<b>Application Ref:</b>	3/2025/0930			 <p>Ribble Valley Borough Council <a href="http://www.ribblevalley.gov.uk">www.ribblevalley.gov.uk</a></p>
<b>Date Inspected:</b>	07/01/2026	<b>Site Notice:</b>	07/01/2026	
<b>Officer:</b>	MC			
<b>DELEGATED ITEM FILE REPORT:</b>				<b>APPROVAL</b>

<b>Development Description:</b>	Proposed erection of 2 no. self-build agricultural workers dwellings with access and parking.
<b>Site Address/Location:</b>	Bolton Fold Farm, Alston Lane, Longridge, PR3 3BN

# PROPOSED PLAN AND ELEVATIONS

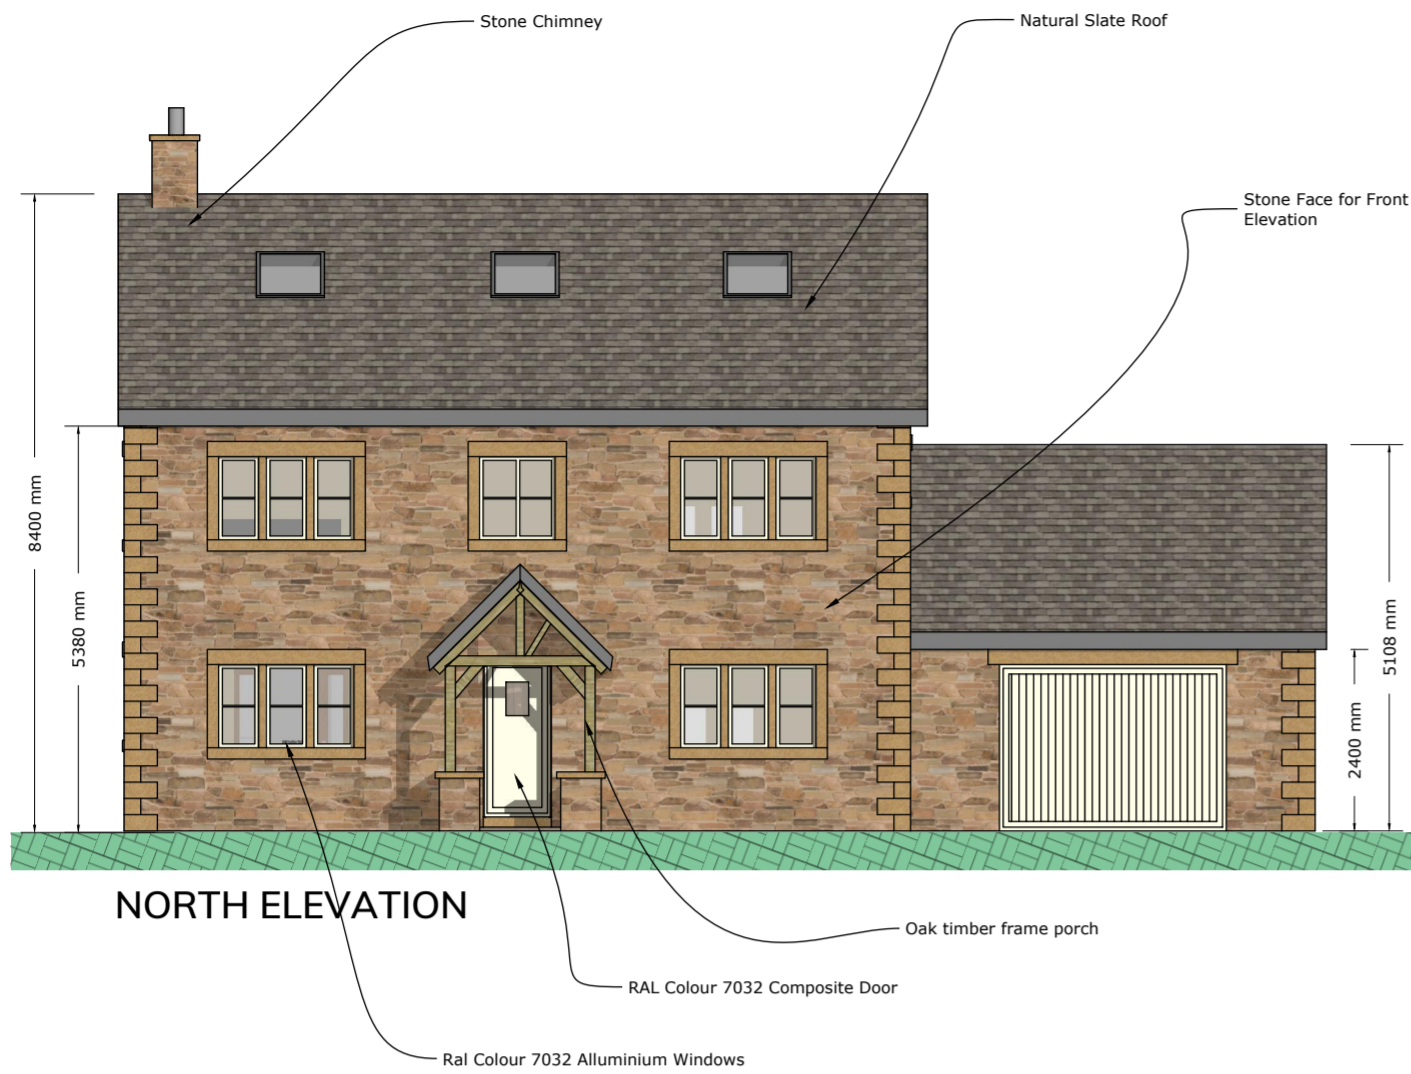
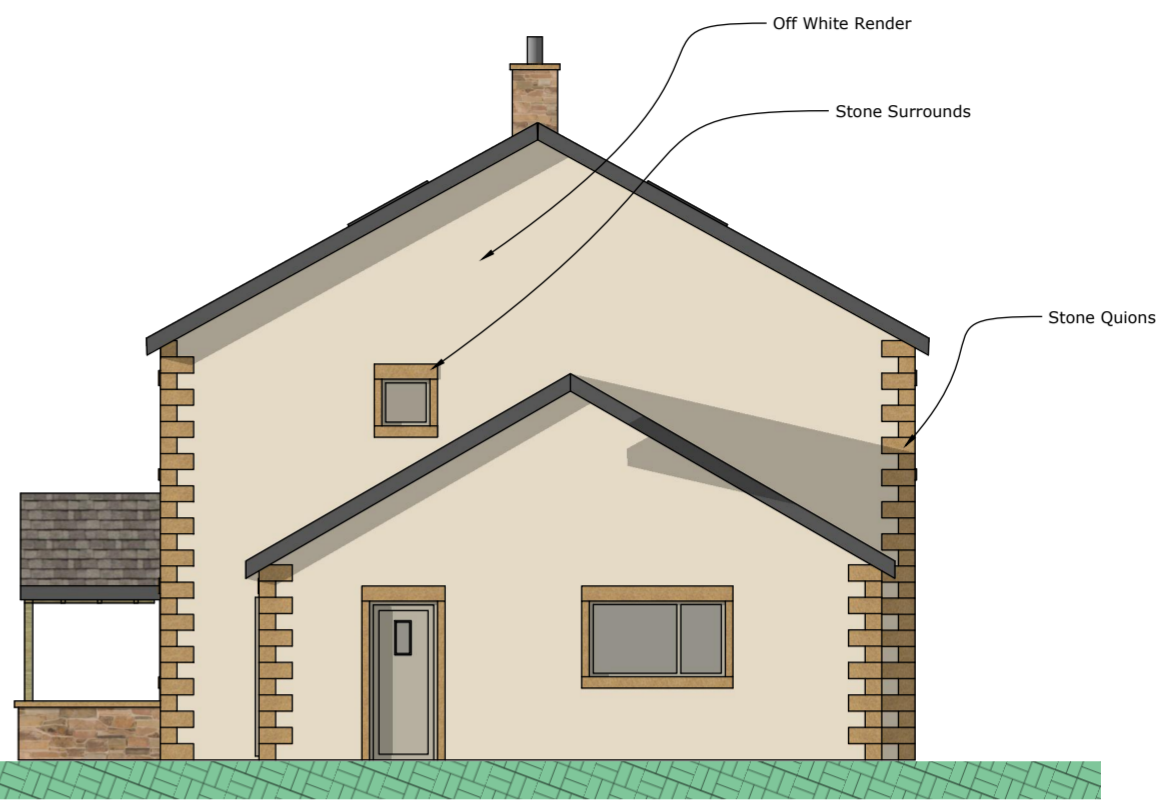
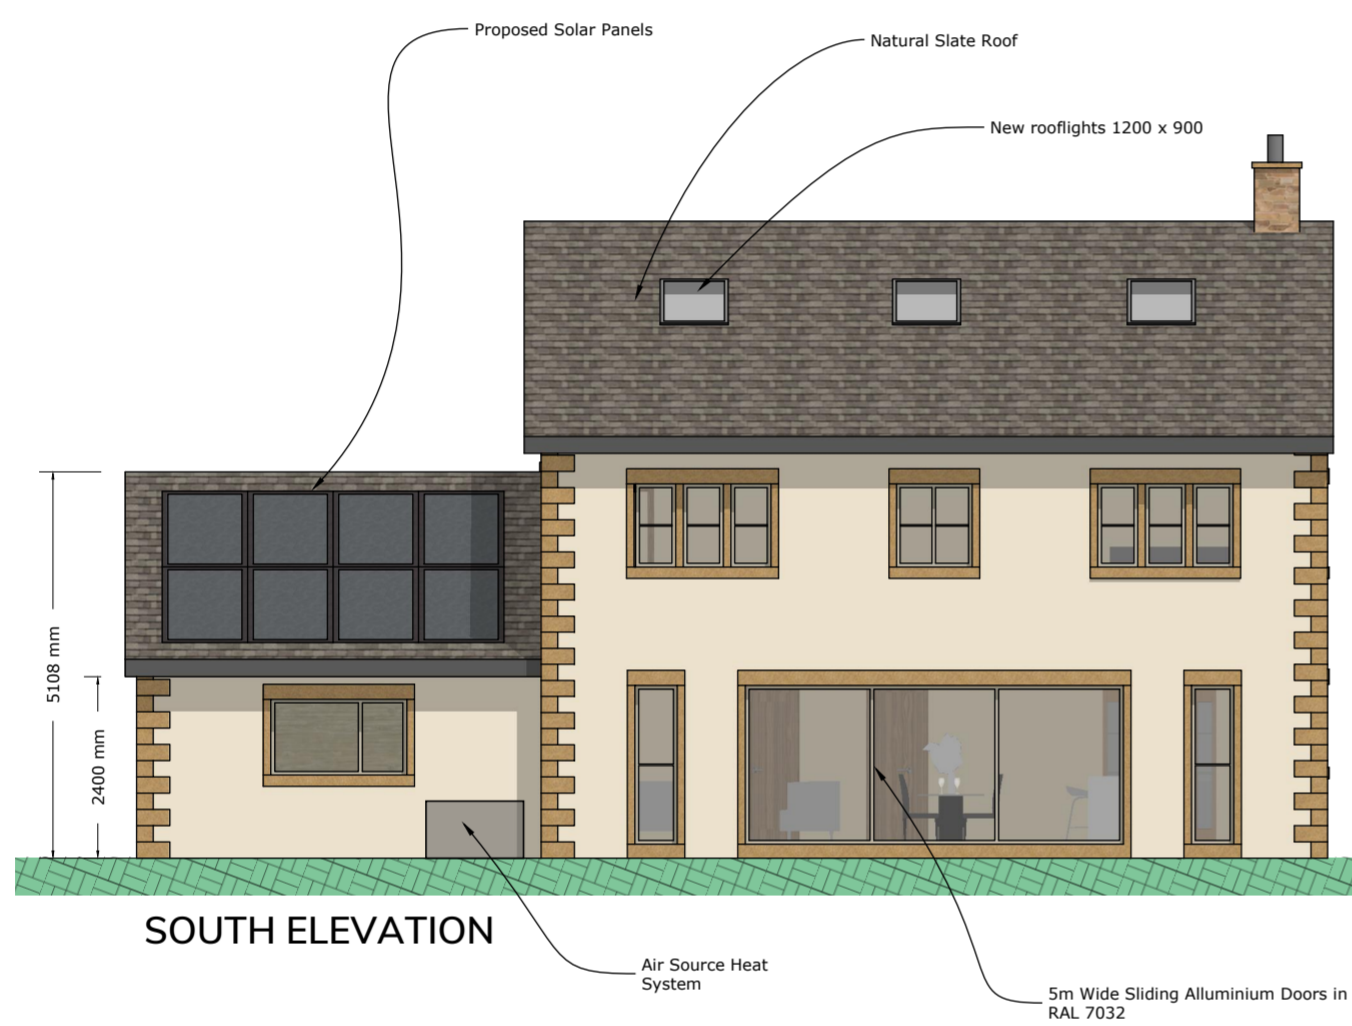
Throughout the course of the application, further amendments have been sought to amend the design of one of the dwellings to include two small gable features to the front elevation roof slope of Dwelling ‘2’ and include half rendering to the front elevation. It is considered that this would help to add interest to the street scene and help to ensure the properties assimilate well with the agricultural landscape.
